# V1Site Development Plan.pdf Markup Summary

Label or remove

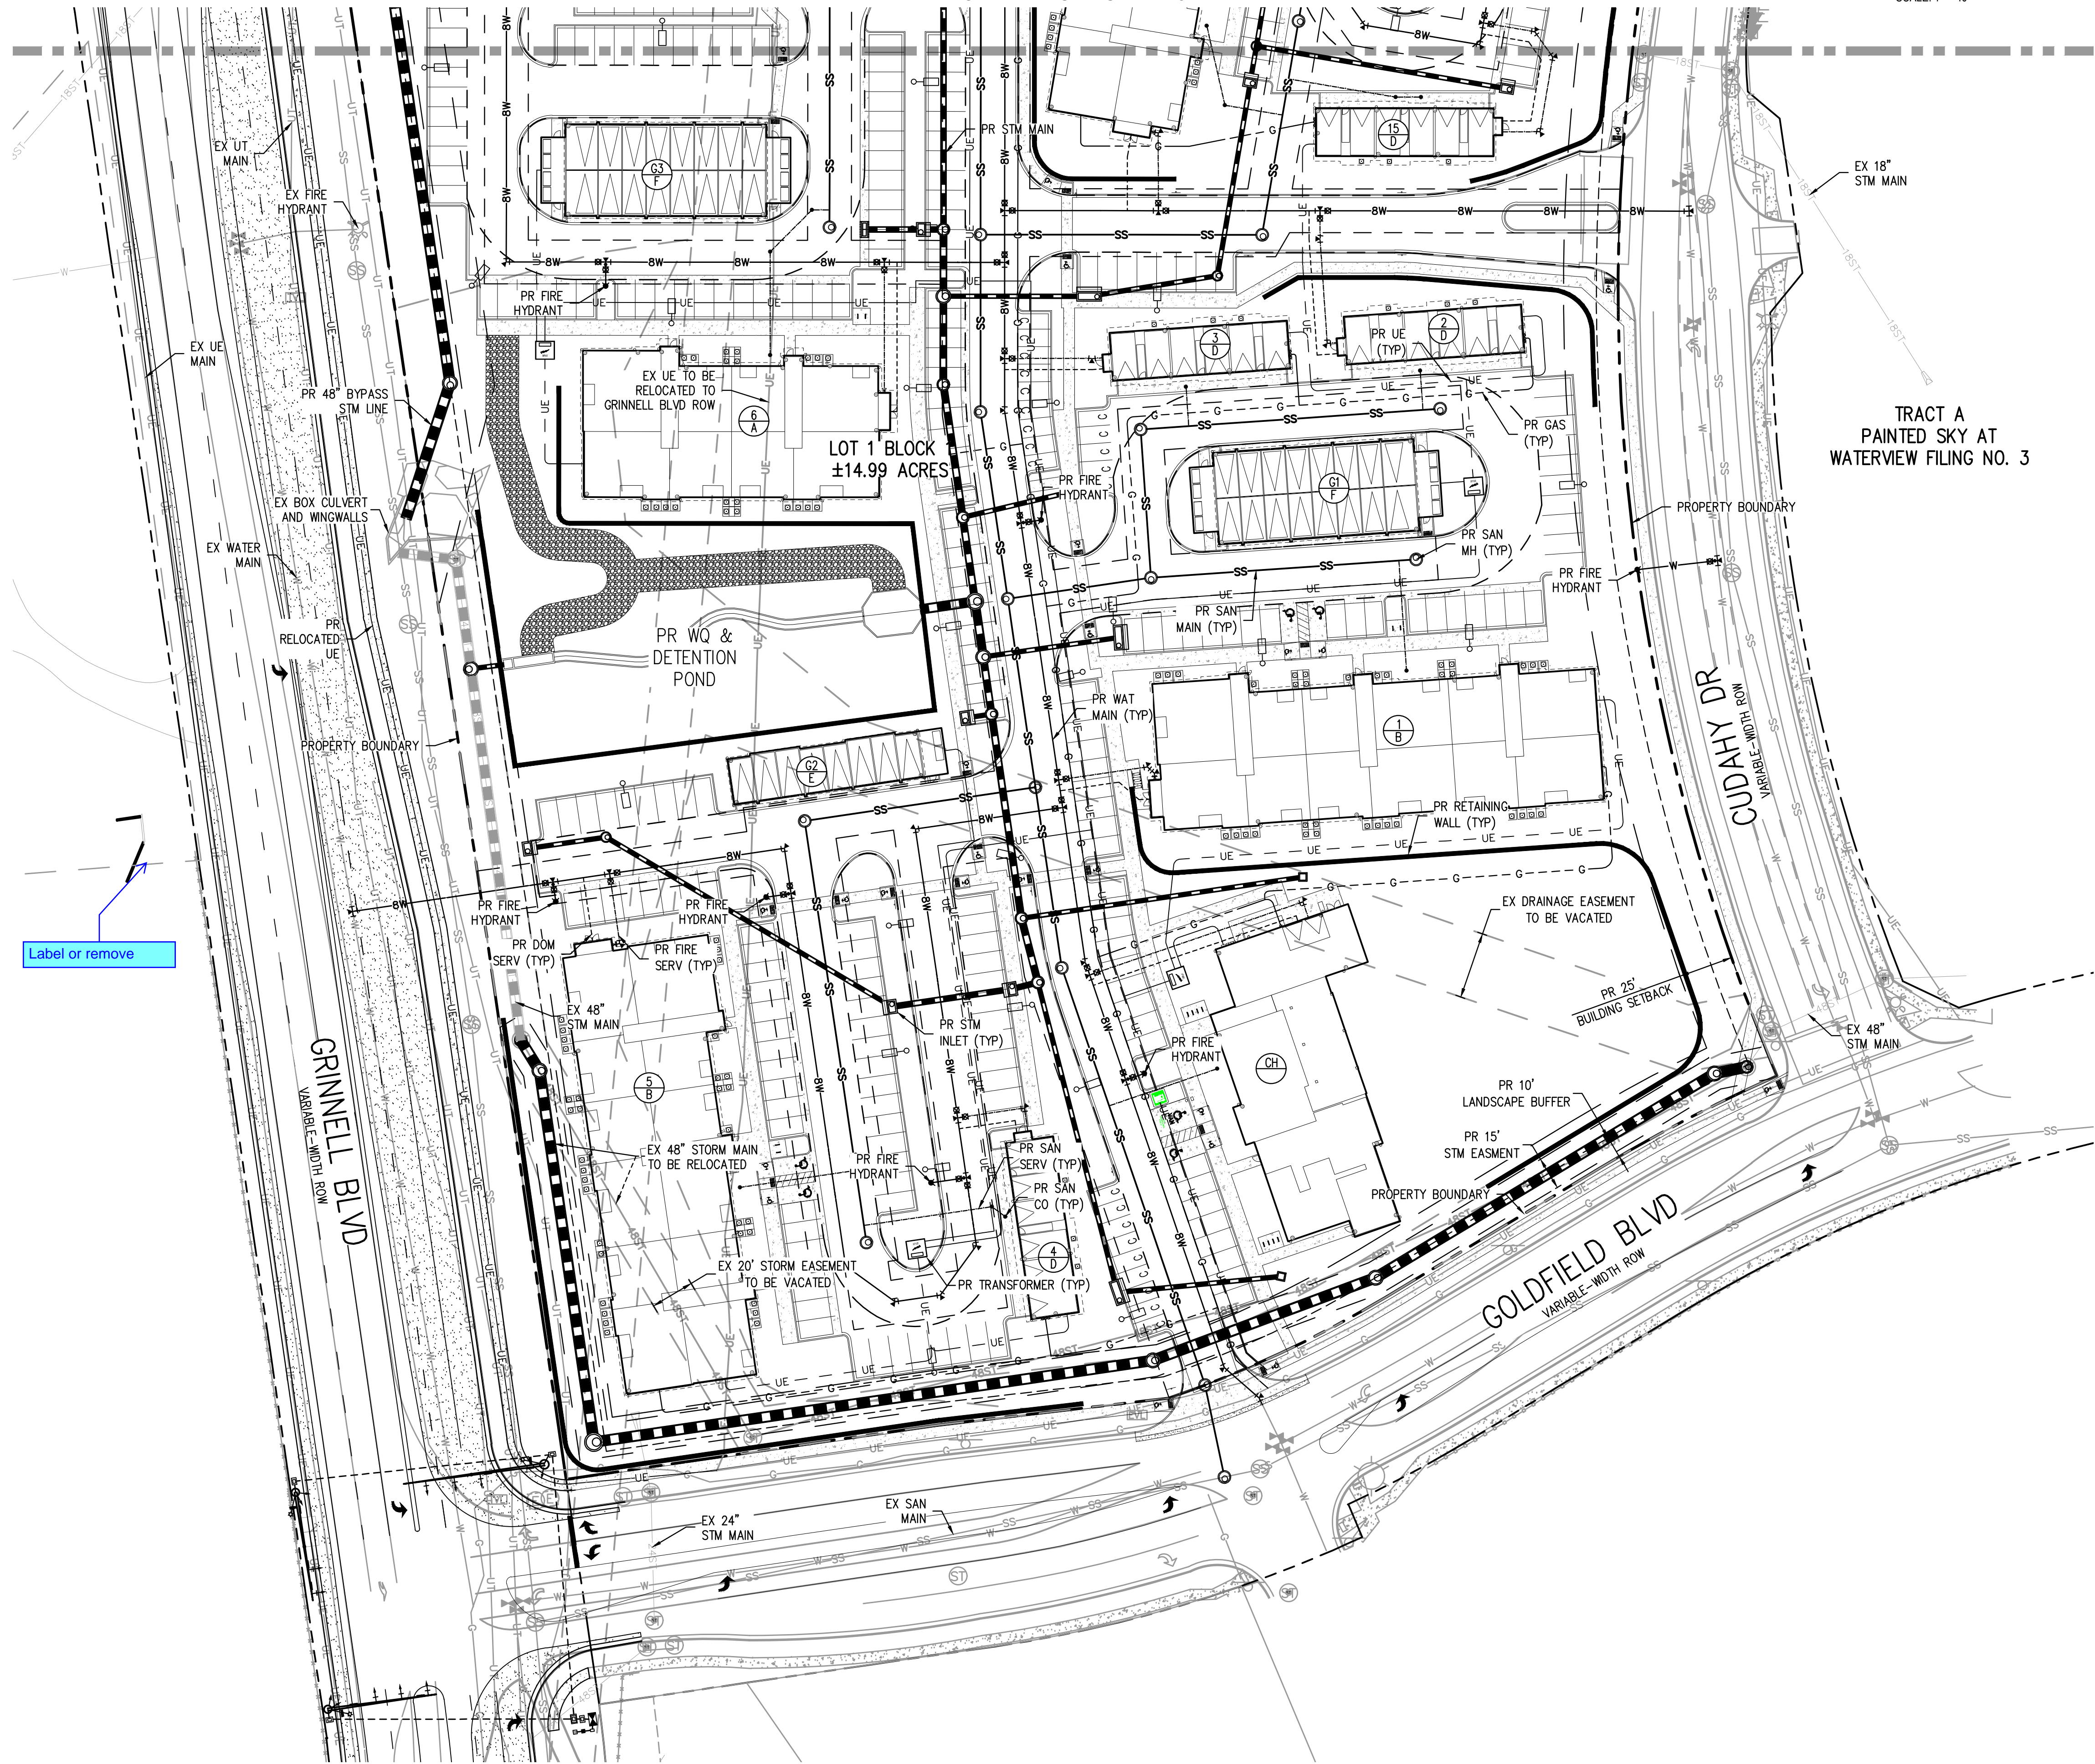
Label or remove
